Inland Rail – Parkes to Narromine EIS – SSI 7475

Thank you for your letter dated 13 July 2017 seeking comment on the above. This response represents a joint submission of Transport for NSW (TfNSW) and Roads & Maritime Services, collectively referred to as TfNSW.

Annexure - Inland Rail Parkes to Narromine EIS

Figure 7.14 Projected growth in train numbers for Inland Rail

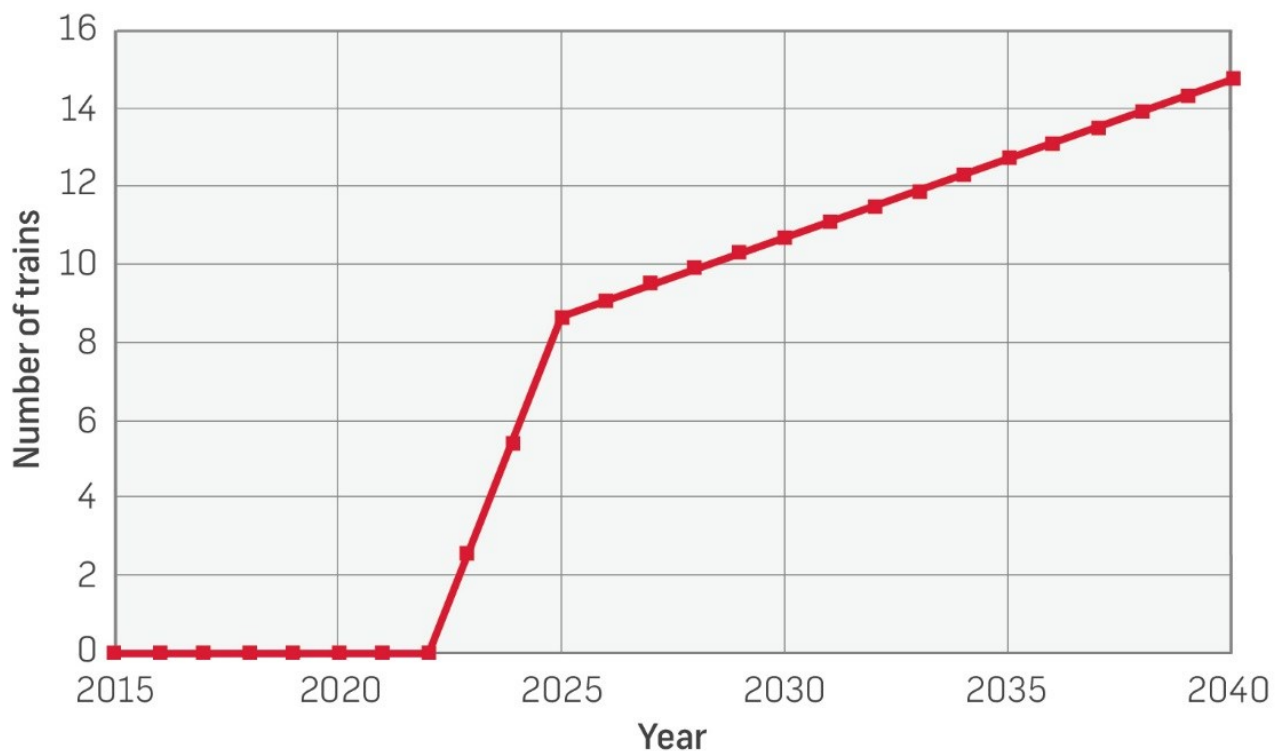
A cumulative assessment of delay on Henry Parkes Way should be presented for the forecast 8.5 trains per day in 2025 or 15 trains per day in 2040. Decelerating trains on the Henry Parks Way Level crossing should be considered (speed potentially below 90km/h) to enter existing and planned intermodal terminals.

**Figure 6.2** *Brolgan Road overbridge options*

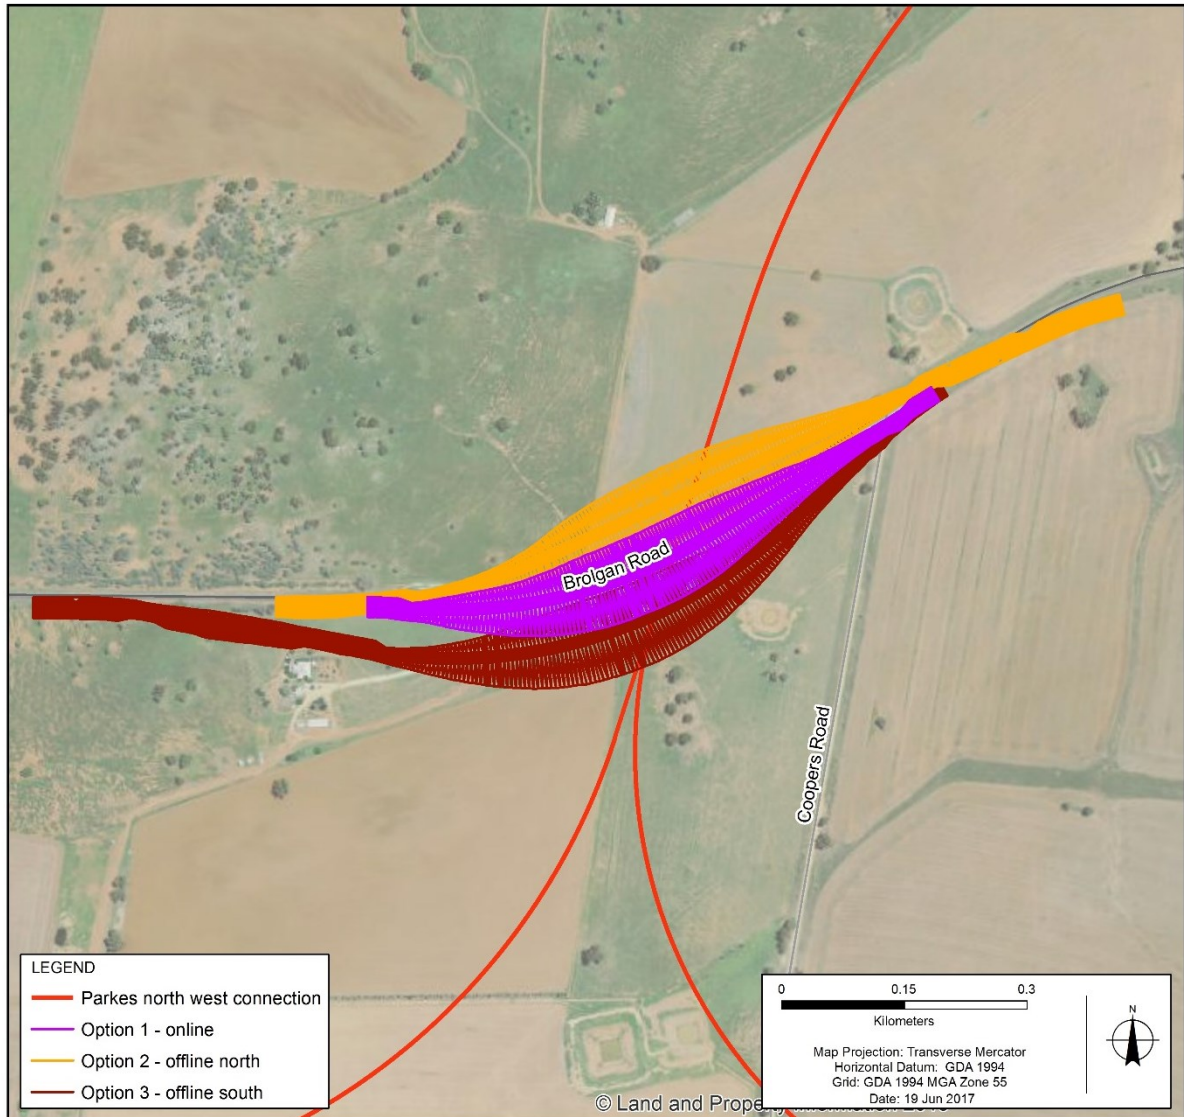
Section 6.3.4 of the Alternatives and Proposal Options assessment report identifies a road over rail bridge as the preferred option for Brologan Road within the preferred option for the Parkes north west connection to the Broken Hill line.

Similar treatment should also be considered for the Henry Parkes Way intersection at the northern end of the proposed connection. Henry Parkes Way carries significantly higher volume of traffic and includes road trains, which are not permitted on Broilgan Road, at the proposed over bridge location. Henry Parkes Way intersection has limited sight distance in both directions (Broilgan Road would only be limited in one direction) and would carry more rail traffic than the connection line that crosses Broilgan Road.
